From: [Vaughn Bray](#)
To: [Jeremiah Cromie](#)
Subject: Fwd: Kittitas County Project: Clear View (SE-21-00017)
Date: Tuesday, August 31, 2021 11:05:52 AM

RE Clear View (SE-21-0017, tax parcel 11884

We are writing concerning the aforementioned project submitted by Mark Couper on behalf of Clear View Aspen Canyon Homes LLC. We are the owners of the easterly adjacent property having the parcel number 17583, and map number 19-14-01000-0016. Our understanding of the application is for a rezone from Forest land use to Rural Residential land use, and a north-to-south easement for a future road between Whisper Creek Drive and Pasco Road / Fowler Creek Road. Our project application comments are as follows.

**CLEAR VIEW ACRES SHORT PLAT
KITITAS COUNTY SHORT PLAT NO. 06-XX
PTN. OF THE WEST 1/2 OF SEC. 1, T.19N., R.14E., W.M.
KITITAS COUNTY, WASHINGTON**

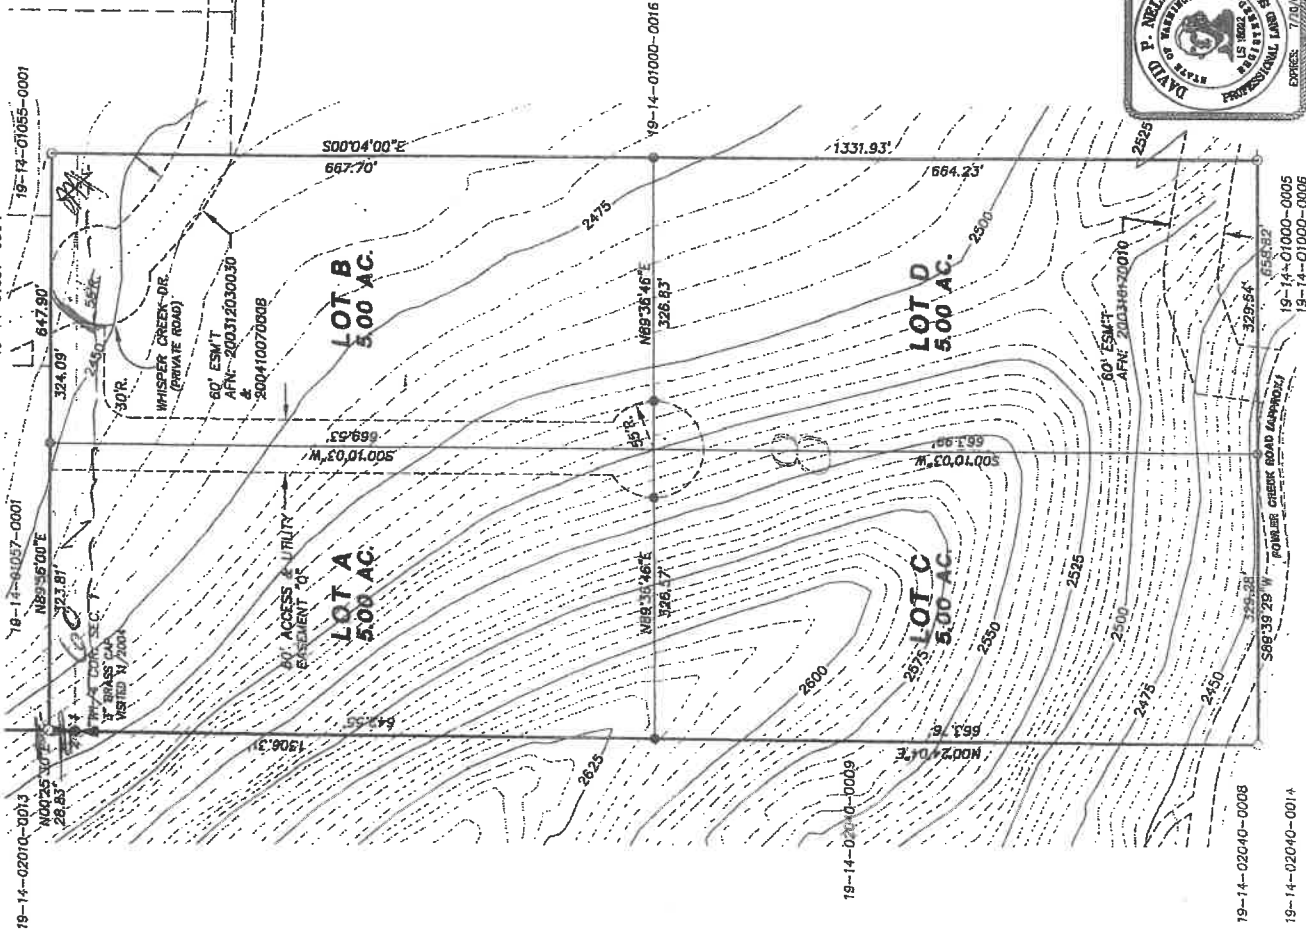
- What status will the County assign to the Applicant's new north-to-south road between Whisper Creek Road and Pasco Road ? Will the County approve this as a "private" road only usable by the short-plat lot owners and guests, or a usable "public common" road for the Westside Heights Homeowners Association residents, land owners, and guests?

- Will the County require that this new north-to-south road between Whisper Creek Road and Pasco Road become another ingress / egress road for the Westside Heights Homeowners Association residents, property owners, and guests? Currently, the ingress / egress road for the Westside Heights Homeowners Association residents, property owners, and guests is from Westside Road.

- Currently, a road and utility easement exists across the southern property

boundaries of adjacent easterly properties to the Applicant. This easement connects Pasco Road and Alpine View Drive. The Applicant uses a segment of this easement for the Applicant's road connection to Pasco Road. I am concerned that the applicant's new road will not allow for an intersection between any future road on this easement and the Applicant's road.

- Will there be an asphalt paving requirement for the new north-to-south road between Whisper Creek Road and Pasco Road. Roads within the Westside Heights Homeowners Association are asphalt paved.
- Can a security gate be installed at the intersection of the new north-to-south road between Whisper Creek Road and Pasco Road?
- We are concerned about the Applicant's response to the question about rainwater or snowmelt runoff from the new north-to-south road onto Whisper Creek Road. Our property is downslope from the applicant's property, and any rain water or snowmelt runoff might overwhelm the existing roadside drainage system and our properties road culvert.
